CITY OF ALBUQUERQUE

January 29, 2013

**Re: Insight Construction Headquarters, 3909 12th St NW,
Request for Permanent C.O. – Not Accepted
Engineer's Stamp dated: 09-28-12, (G14/D083)
Certification dated: 01-25-13**

GRADING & DRAINAGE PLAN
SCALE: 1"=20'

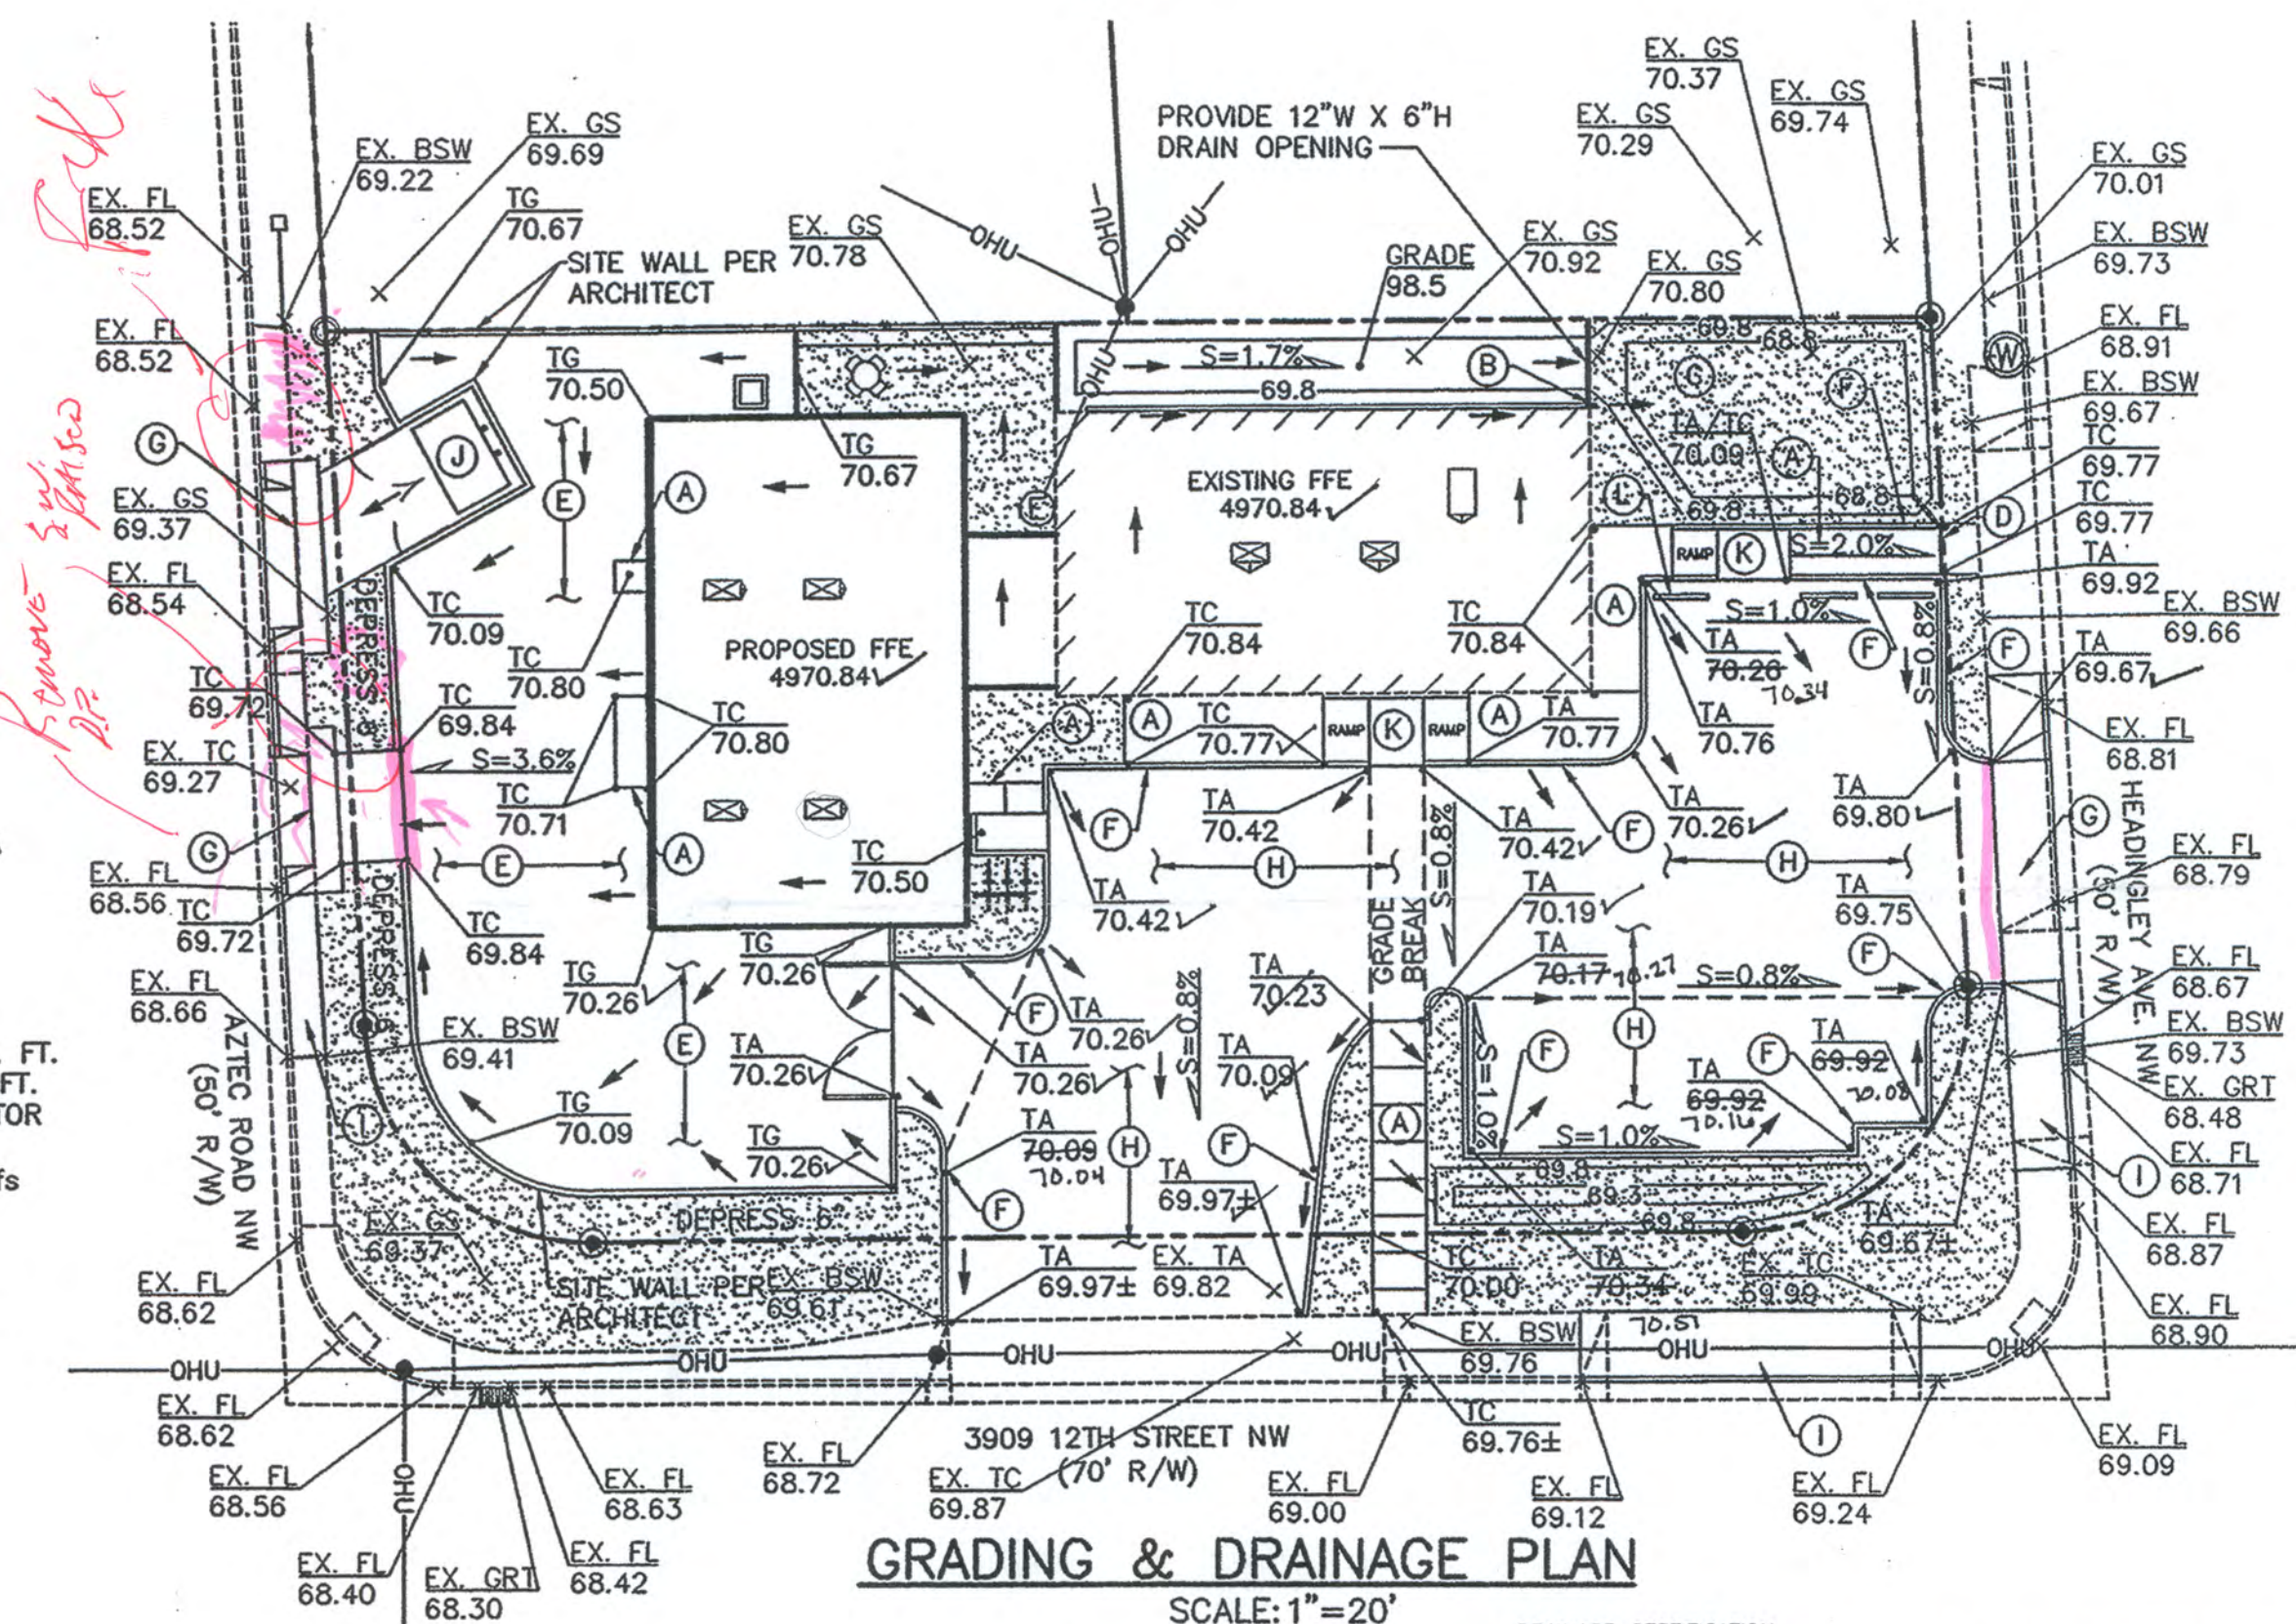
1. The existing drive pad and sidewalk along Aztec Road will need removed and replaced with standard curb and gutter, (per COA Specifications 2415A & 2415B); the sidewalk will need replacing also, (per COA Specification 2430).
2. The drive pad at the refuse enclosure will required narrowing to conform to the design.
3. The drive pad on Headingly Avenue does not meet COA Detail 2425. Please ensure the three feet at two percent cross slope is achieved.
